Your Ref: OWPC22955
Our Ref: M/32/19/PL 10-04-2019
Please ask for:
Mrs A Gardner

New dwelling & separate garage replacing the proposed new house in the previous
planning permission ref: M/7/16/PL - Amendment to M/153/18/PL

46 Sea Lane Middleton-On-Sea

**Elevation Materials
South**

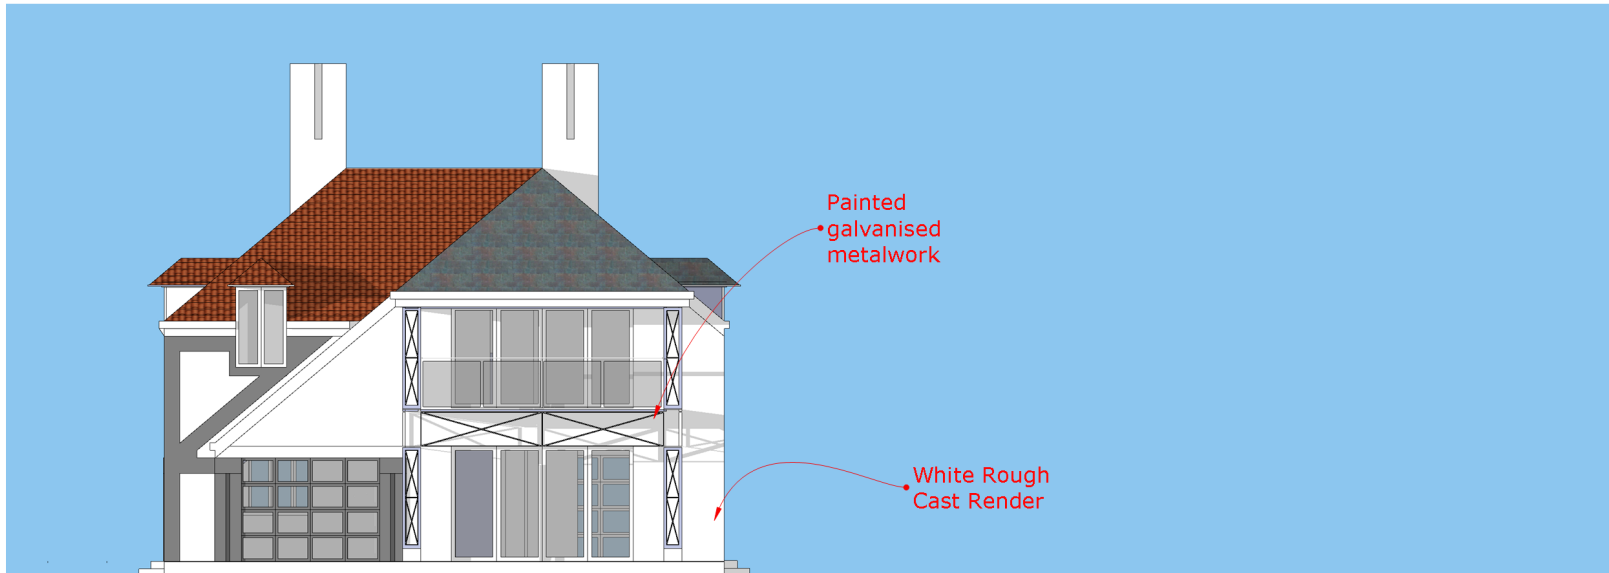
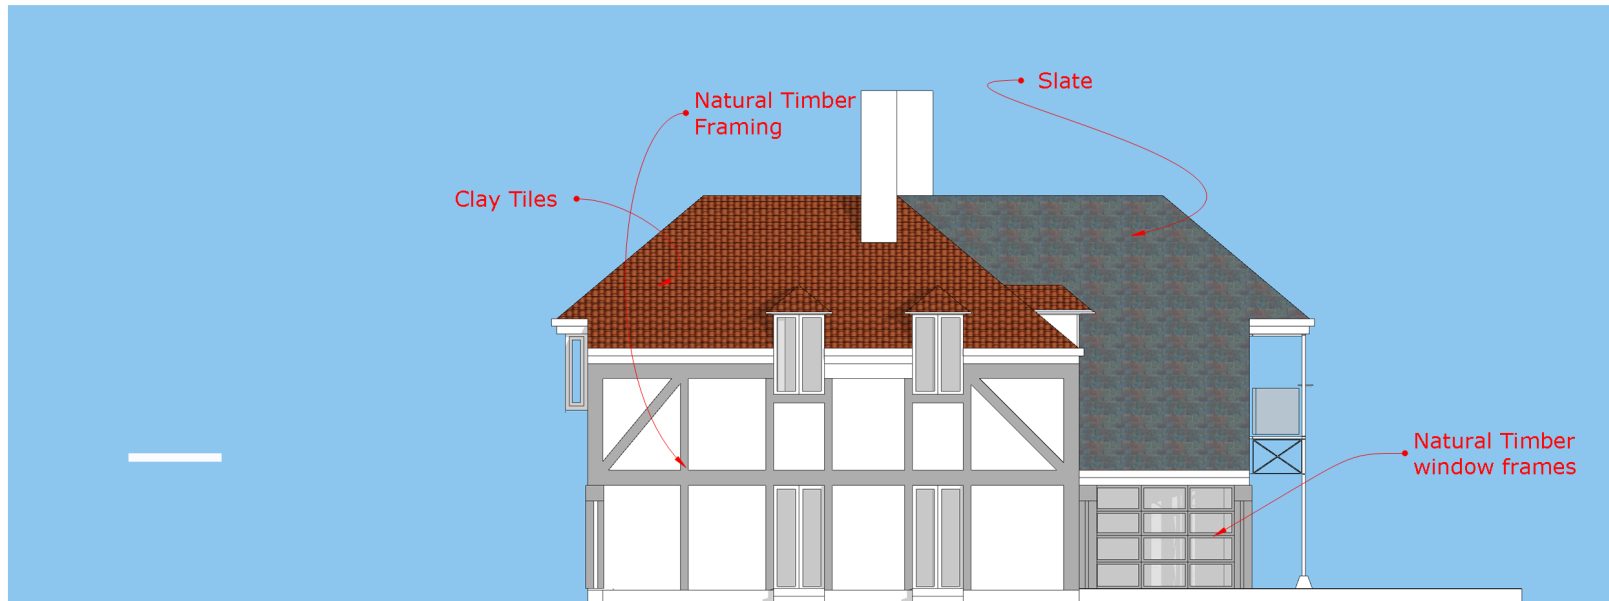
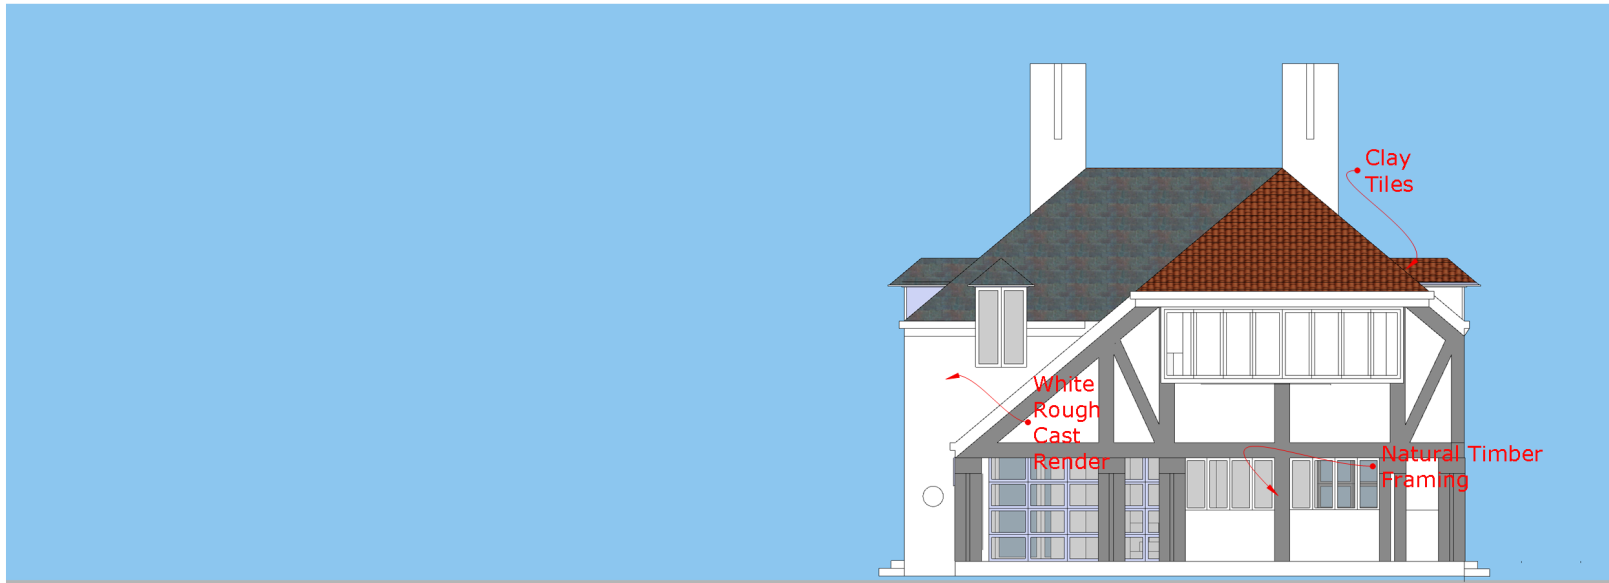
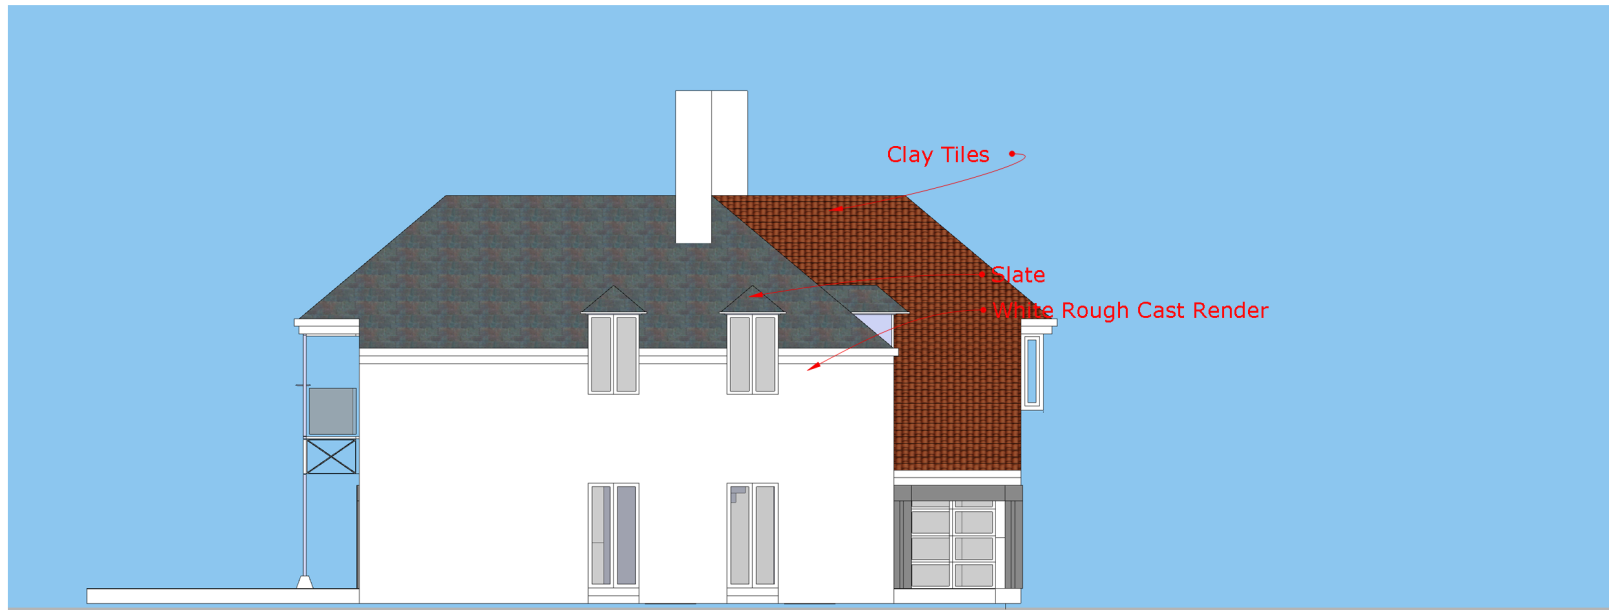
*is the tile/slate roof an architectural feature or a structural requirement? I would prefer a
fully tiled roof & object on this basis.*
